# Charlotte Department of Transportation

## Memorandum

**Subject:** Rezoning Petition 08-153: Located on the northeast corner of University City Boulevard and Sams Lane (revision received 11/17/08)

**RZ1.0**

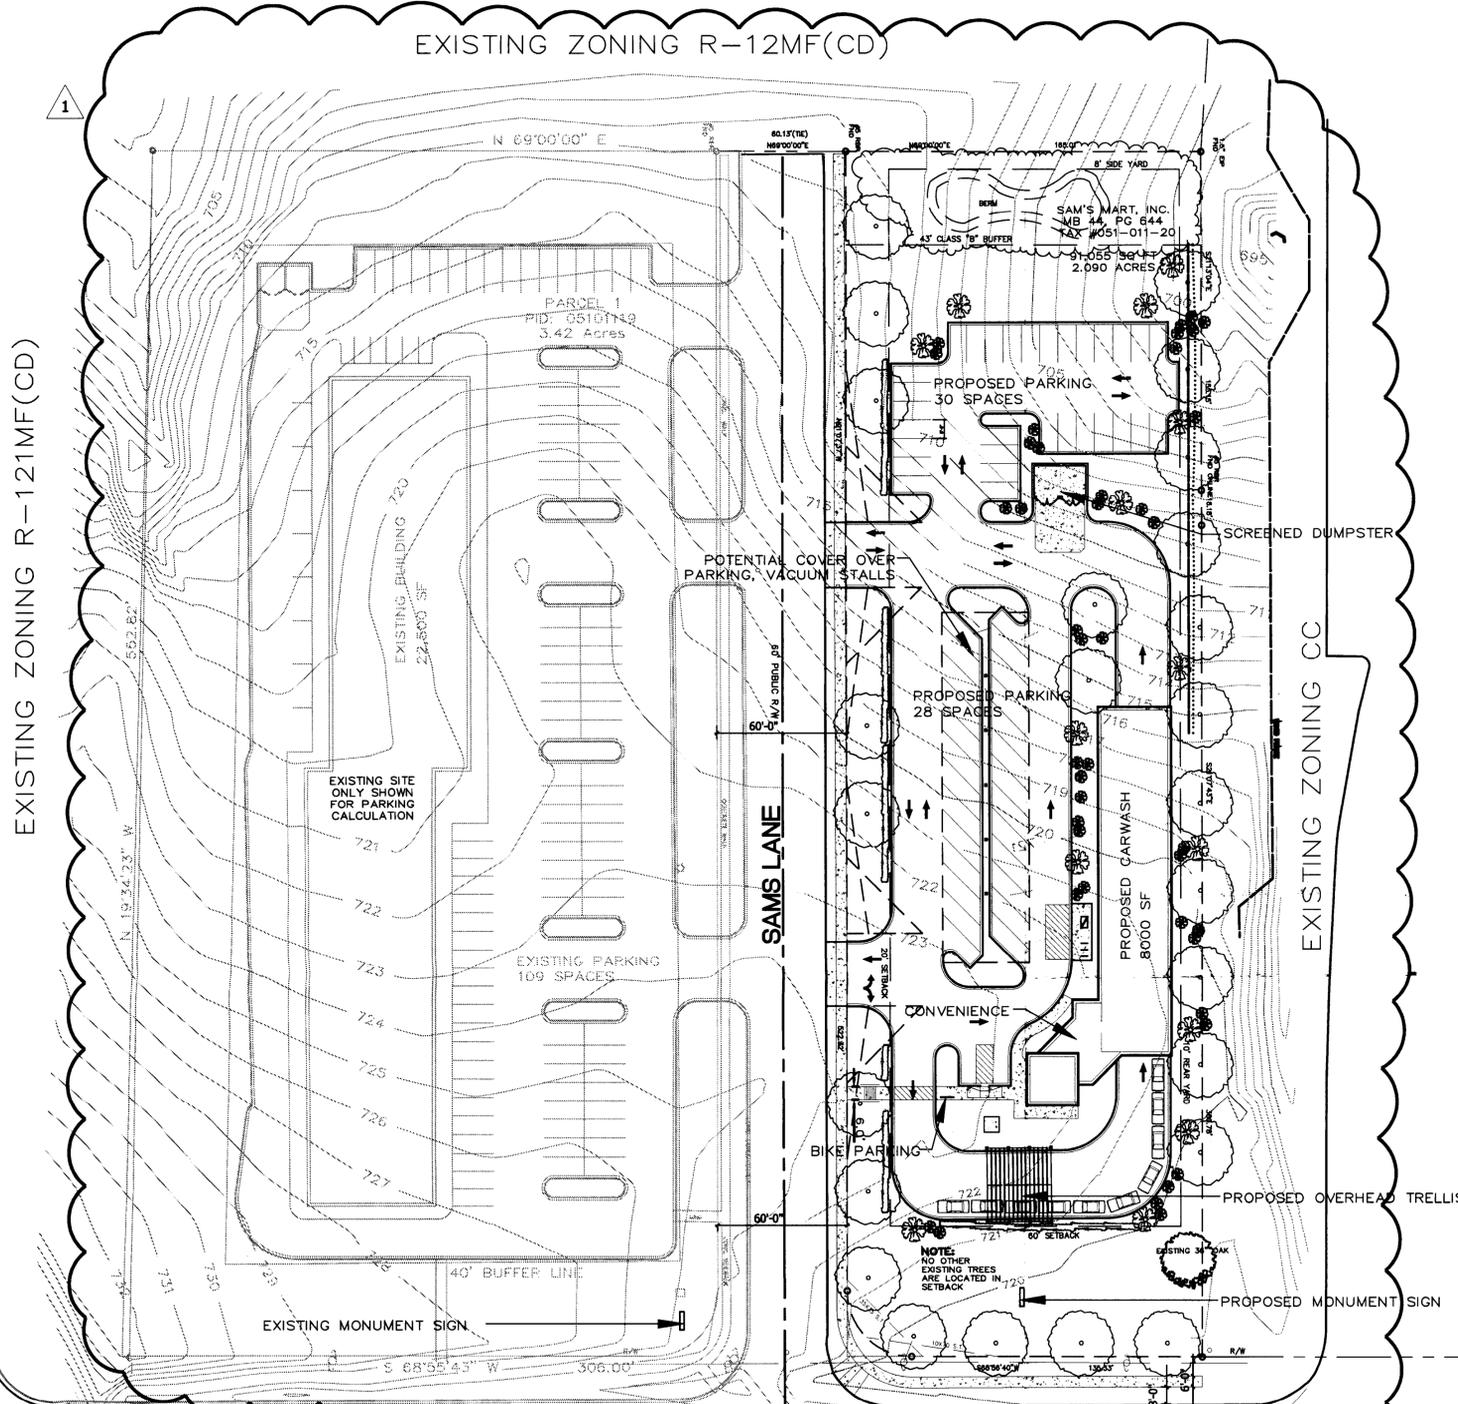
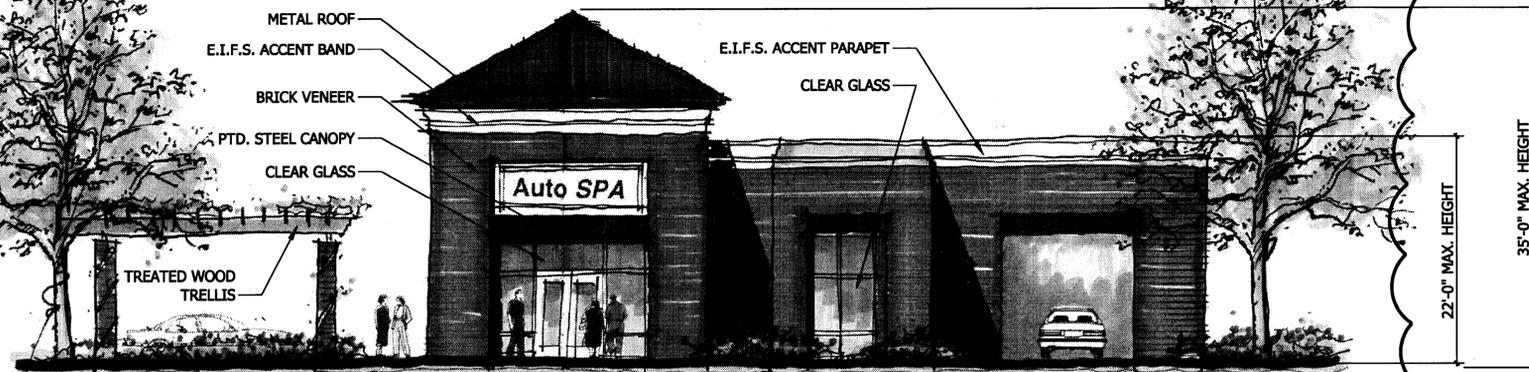
1. Two-way drive aisles are not permitted with angled parking spaces. The drive aisle must be changed to one-way operation or the parking stalls must be 90 degrees.
2. We cannot support the parking area circulation for the proposed carwash as shown on the site plan without the deletion of the first driveway. (*Previous review comment*)

3. Sams Lane is a public street. It appears that the sidewalk on this parcel is not located within the right-of-way. The width of the street (f/c to f/c), planting strip, sidewalk, and right-of-way needs to be shown on the site plan. If the sidewalk falls outside of the right-of-way, a sidewalk easement will need to be provided and shown on the site plan to include that portion of the sidewalk and an additional two feet for maintenance purposes. *(Previous review comment)*

4. Although the vehicle length does not match the drawing scale, it appears that the vehicle stacking for the carwash does not conflict with any required parking spaces and circulating drive aisle. This item will be further reviewed during the building/driveway permit process. *(Previous review comment)*

5. The developer needs to construct 8-foot planting strips and 5-foot sidewalks along Sams Lane. *(Previous review comment)*

1. Drive aisles through parking lots should be designed to avoid minor offsets. The configuration of the drive aisles to the northern-most parking areas needs to be better aligned for through movements. *(Previous review comment)*
